From: Neil Whitton
Sent: 10 July 2019 09:46
To: Michael Sackey
Cc: DC Support
Subject: 19/01170/F - Wendlebury Village Hall Main Street Wendlebury Bicester OX25 2PS

Environmental Protection has the following response to this application as presented:

<p>NORTH</p>	Client Village Hall	Title Proposed plans	
	Project Village Hall Wendelbury Oxfordshire	Scale 1:50	Drawing No BW006 / 04

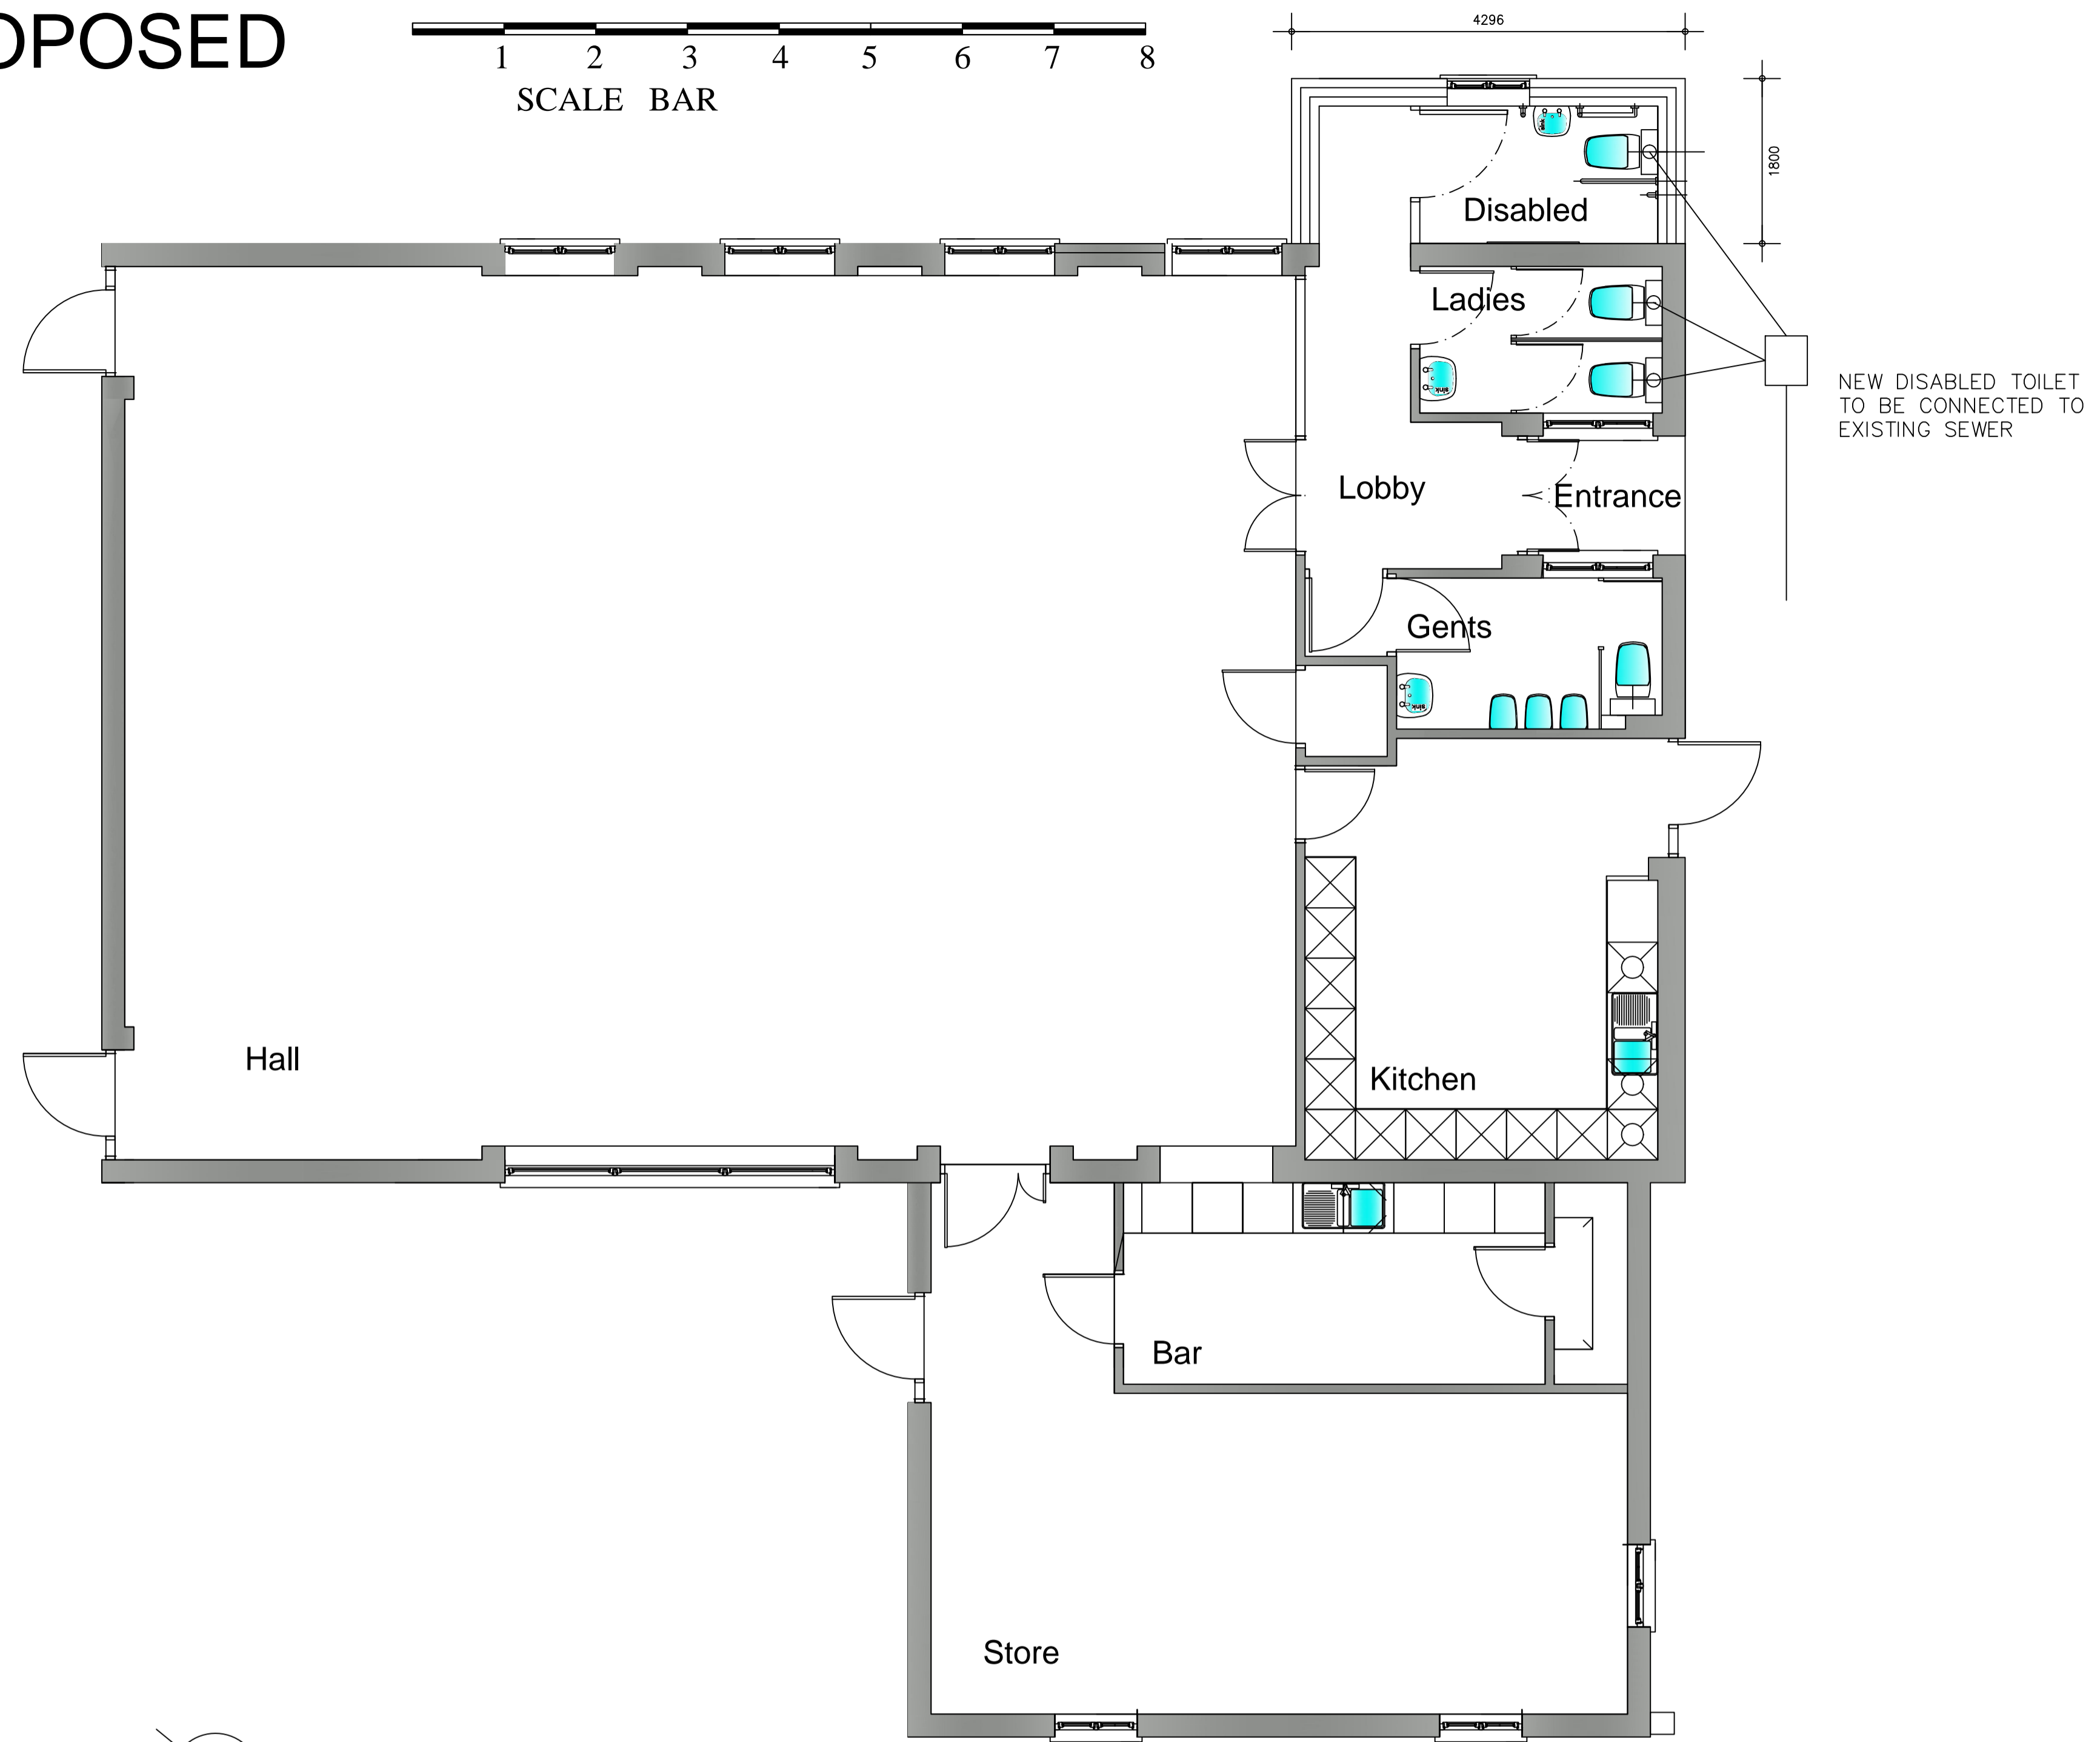
Noise: The proposed Bi-Fold doors should be kept shut when entertainments that could cause a nuisance to nearby residents are taking place inside the hall.
